Selina Poyner
27 Rosalind Street
Cammeray NSW 2062
1 April 2026

Submission: Formal objection to the Cammeray Seniors Living development (SSD-96505456)

DRAWING TITLE
LOWER GROUND - PROPOSED PLAN
 DRAWING NUMBER
 DA-101
 REVISION
 A

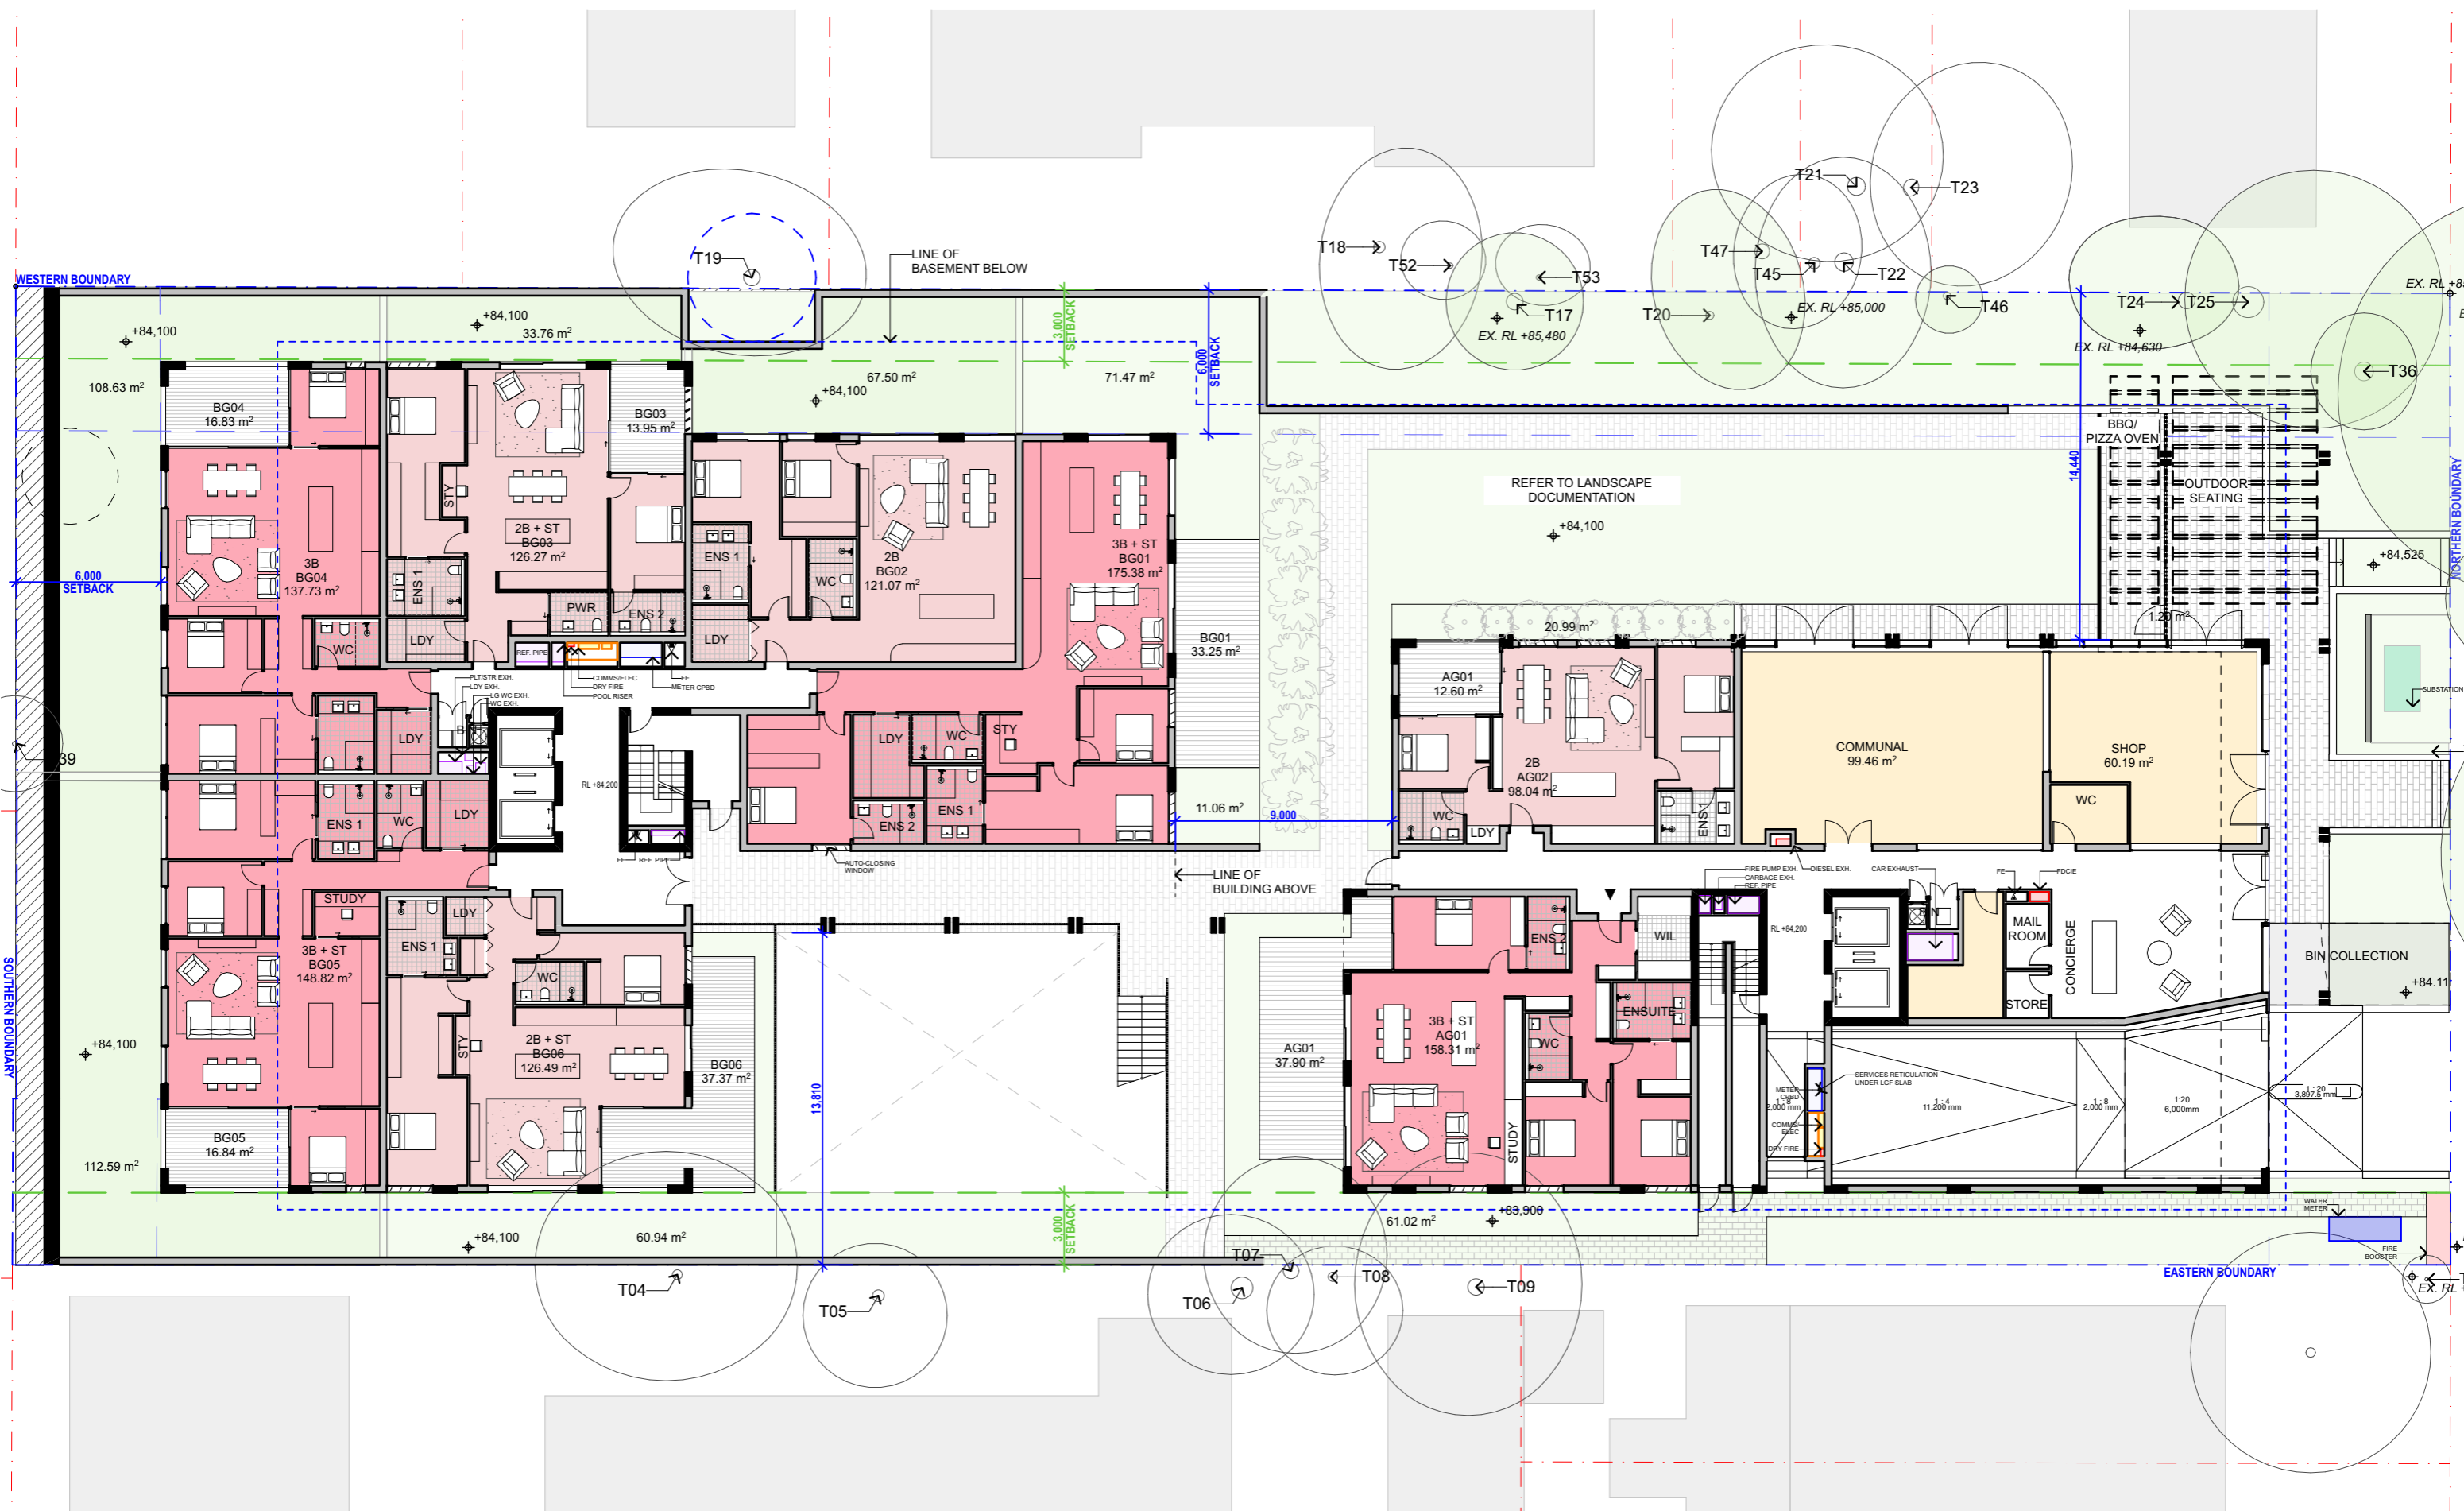
In Image 12 below, the areas highlighted in yellow identify locations where no privacy measures are proposed, further demonstrating the lack of effective mitigation to protect my privacy. The area marked in blue identifies the car park entry, which also requires appropriate acoustic treatment and light spill mitigation to address impacts on my home.

The basement ramp is close to the eastern boundary, concentrating noise and light impacts (engine noise, tyre squeal, headlights and roller door movements) beside my home. This is unnecessary given the site's street frontage. Relocating the driveway further from the eastern boundary (e.g., toward the centre) would reduce noise/light spill and improve sightlines on the pedestrian route to Anzac Park Public School (which is located ~250 m from the site). If relocation is not required, conditions should require effective buffering, including a solid 2.4 m acoustic barrier along the ramp's eastern side and baffles/hooding to ramp and driveway lighting to prevent headlight glare toward No. 27.

Figure 48 indicative residential flat building siting at 27 and 29A Rosalind Street

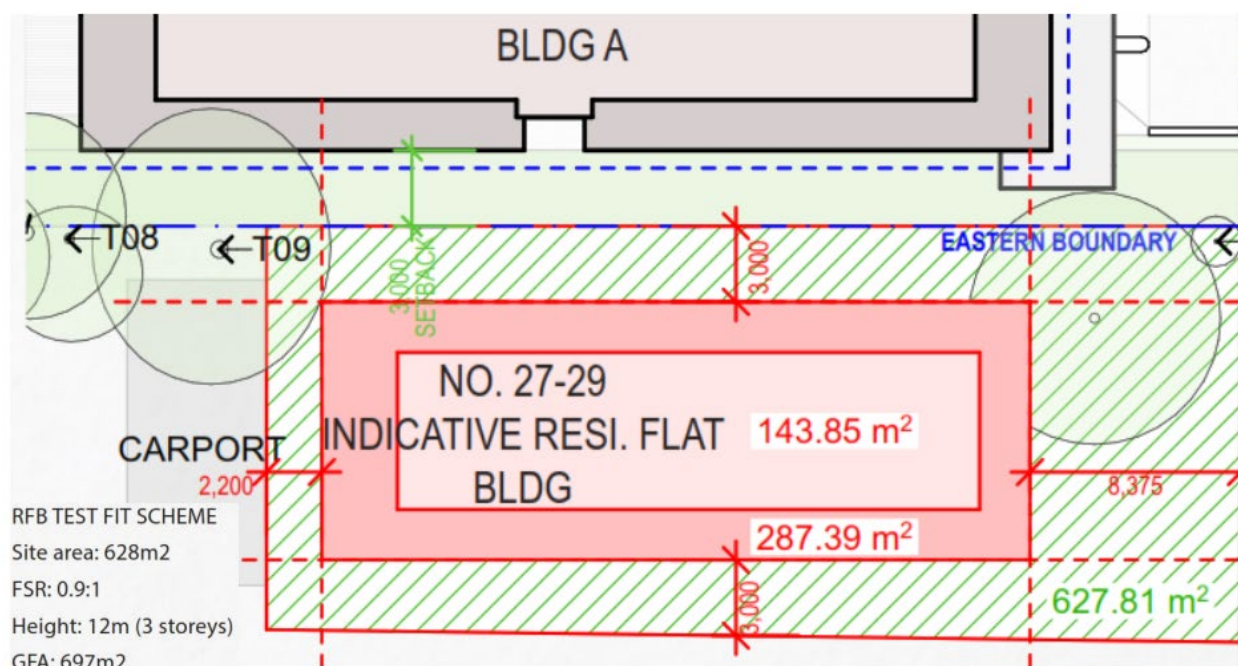
4. **Site isolation (Clause 6.12):** The proposal would isolate 27 Rosalind Street as an undersized remnant lot that cannot reasonably be redeveloped to the intended R4 outcome, contrary to Clause 6.12 under the North Sydney LEP.
